**Planning Application Reference No.:** 3/2022/0568

**Address of Development:** Land to rear of Malt Kiln Brow, Chipping.  
PR3 2GP

**Proposal: Erection of 4 new 2 storey residential dwellings with new access taken from Fish House Lane with associated earthworks and landscaping**

**Location; Land to rear of Malt Kiln House, Malt Kiln Brow, Chipping PR3 2GP**

PROJECT				
Proposed Residential Development at Malt Kiln Brow, Chipping.				
DRAWING TITLE				
Flex MSE Retaining Wall Proposed Section				
DATE	SCALE	DRAWN	DRWG No.	REV
Dec 2022	1:25	GEGH	SKETCH01	A

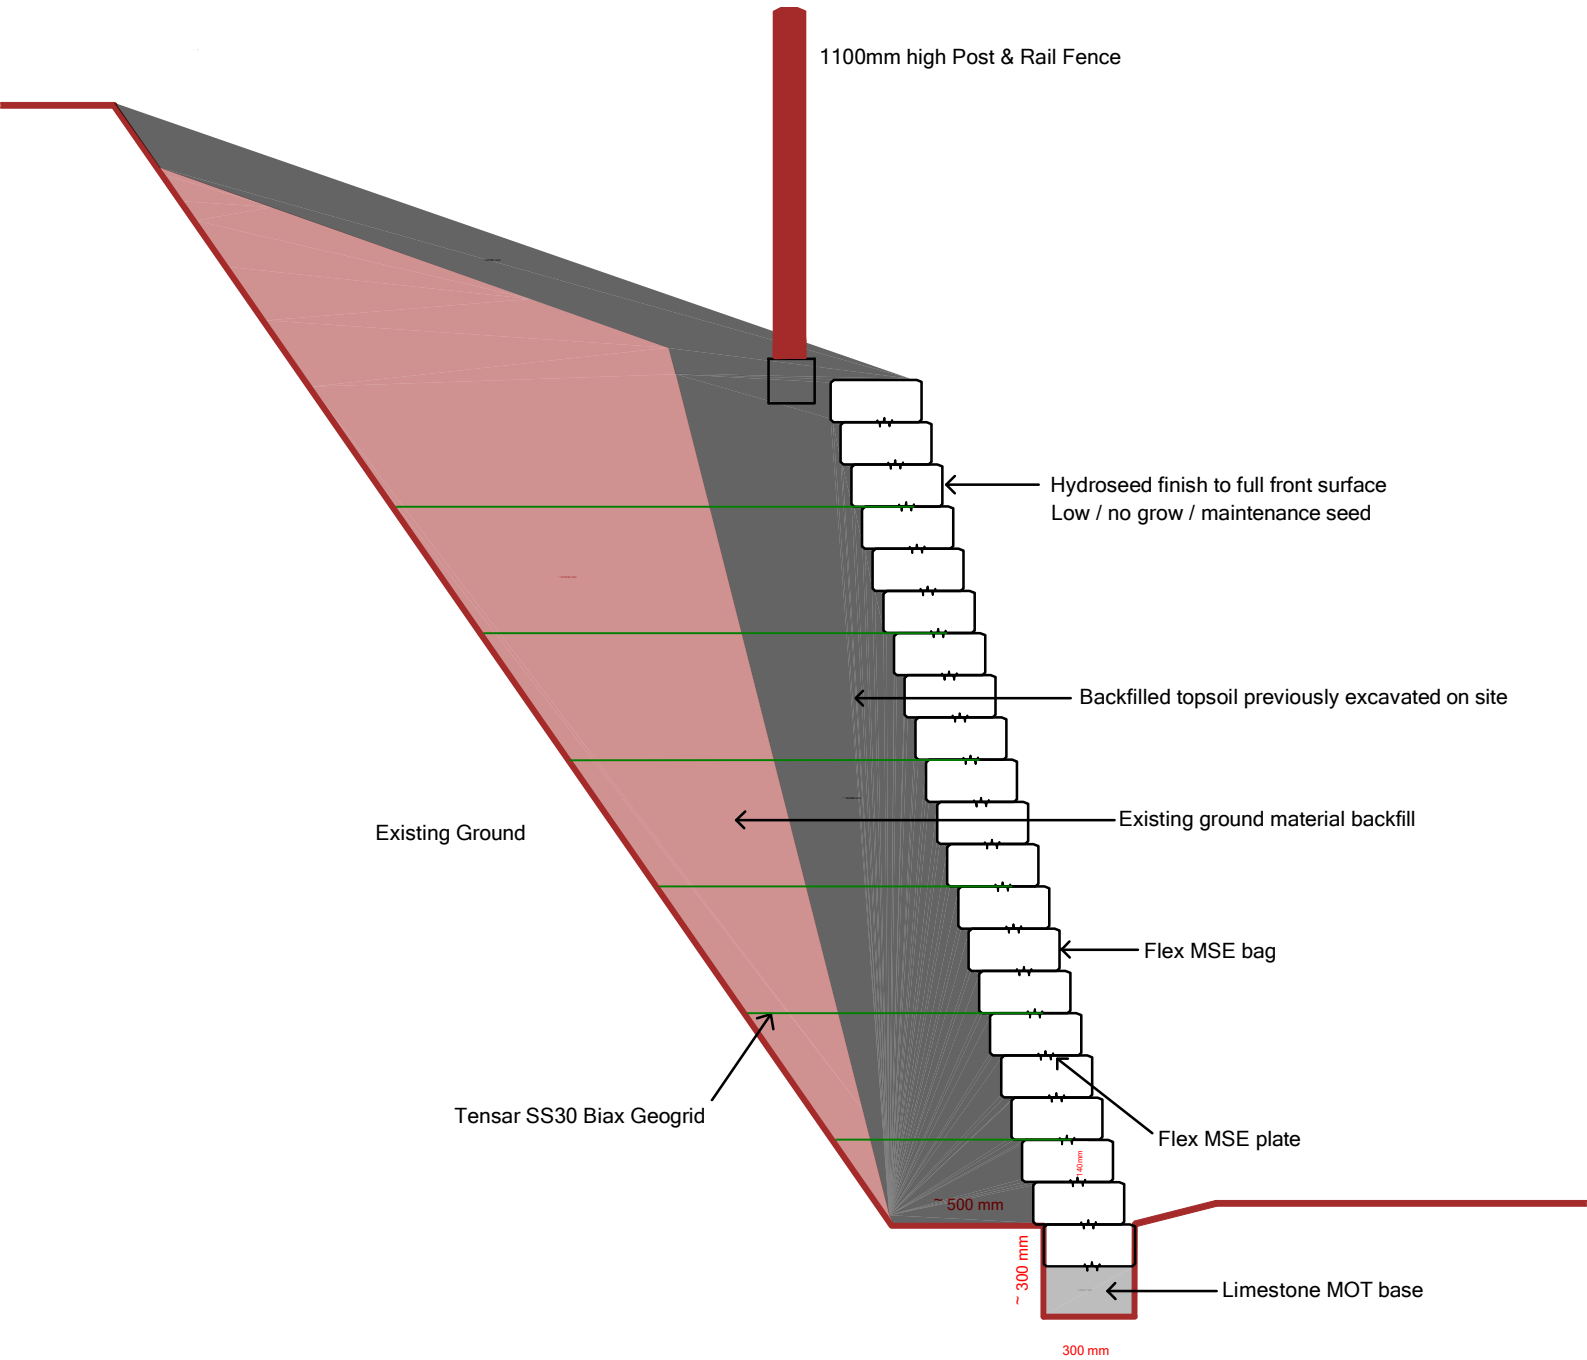
- **Risk to protected trees and wildlife disturbance** – There are large protected trees very close to the retaining wall and I am concerned that their stability and root system could be affected by this, even with the replacement FlexMSE design. We have already lost a significant part of the Millennium Wood as well as hedgerow due to this hybrid development and it is important that any remaining should be preserved. What will be the effect on the wildlife in the surrounding Biological Heritage site, conservation area and watercourse from noise, pollution, land disturbance, light and vibration?

PROJECT Proposed Residential Development at Malt Kiln Brow, Chipping.				
DRAWING TITLE S278 Highway Works - General Arrangement				
DATE Aug 2022	SCALE As Shown	DRAWN SDH	DRWG No. MKB/P07	REV B

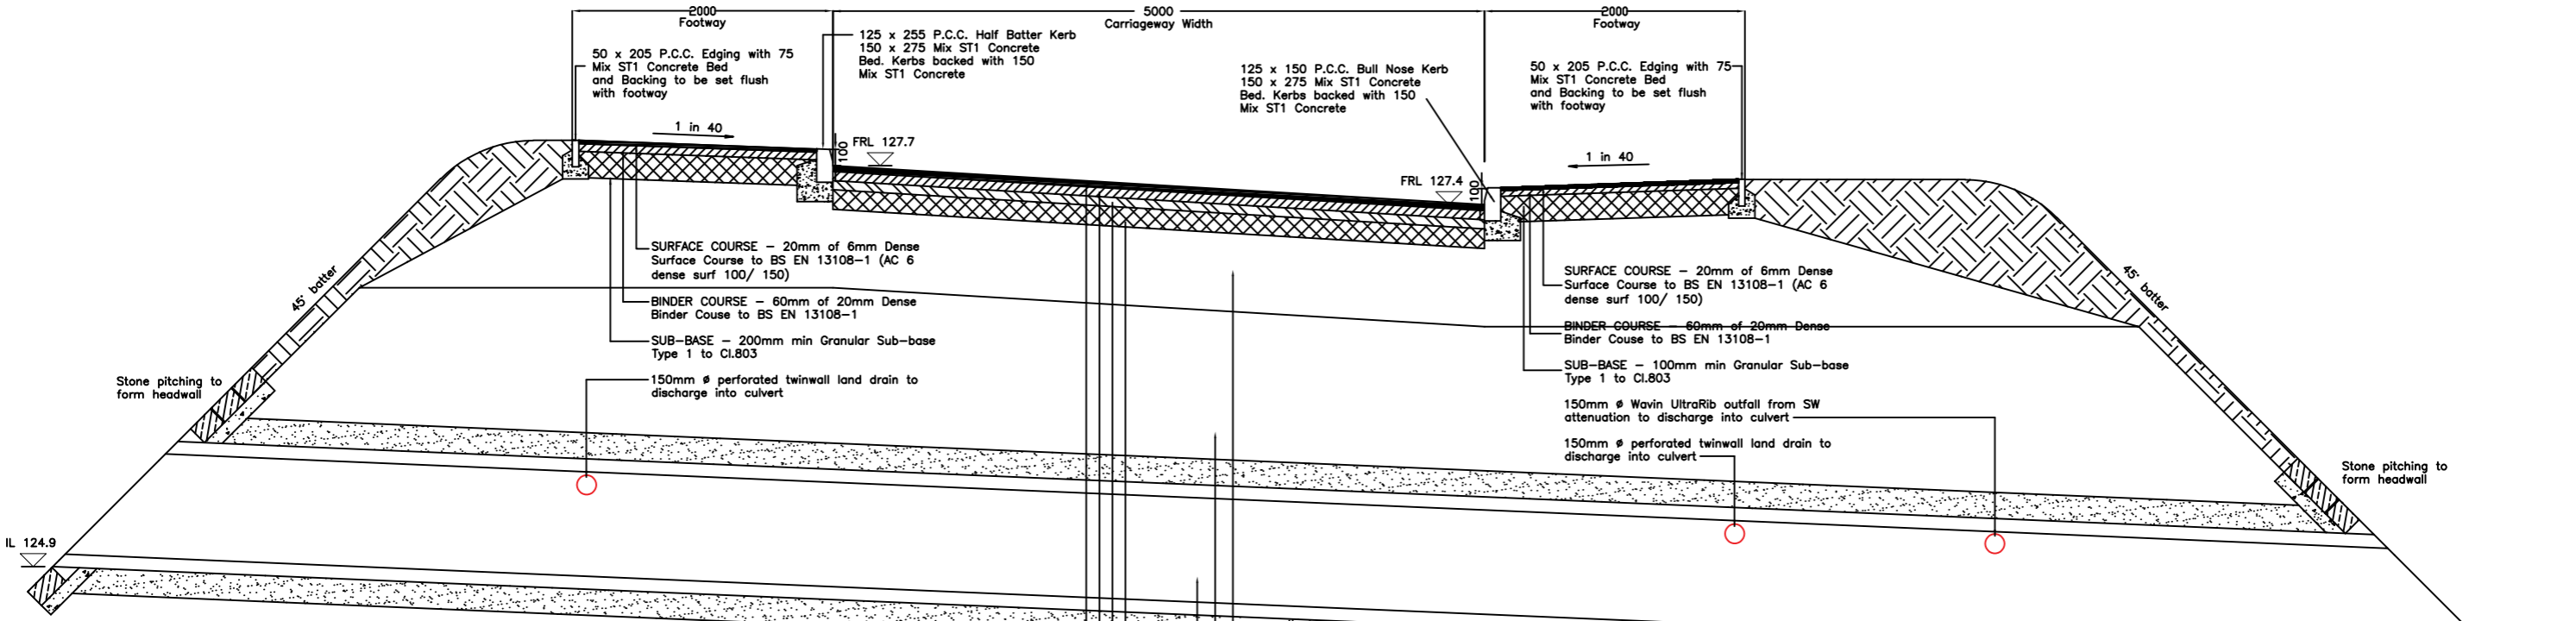
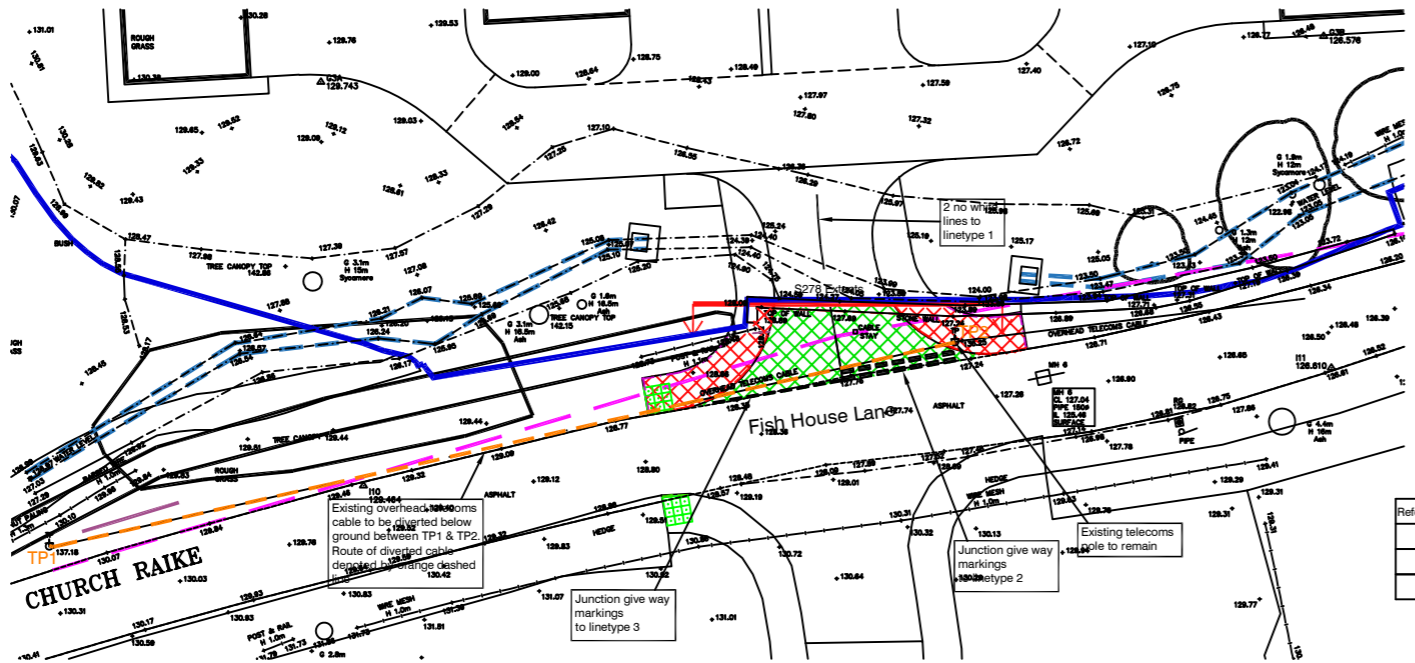
*“The proposed new access on Fish House Lane requires additional information to determine its suitability including visibility splays....”*

Church Raike/Fish House Lane measure approximately 4.4 metres in width from the wall bordering the proposed site and the entrance to Mills Way. Visibility is poor exiting Mills Way onto Fish House Lane both for walkers and drivers alike. The fact that it “appears” less dangerous than the original proposed entrance on Malt Kiln Brow is hardly a ringing endorsement for construction and highways integrity.
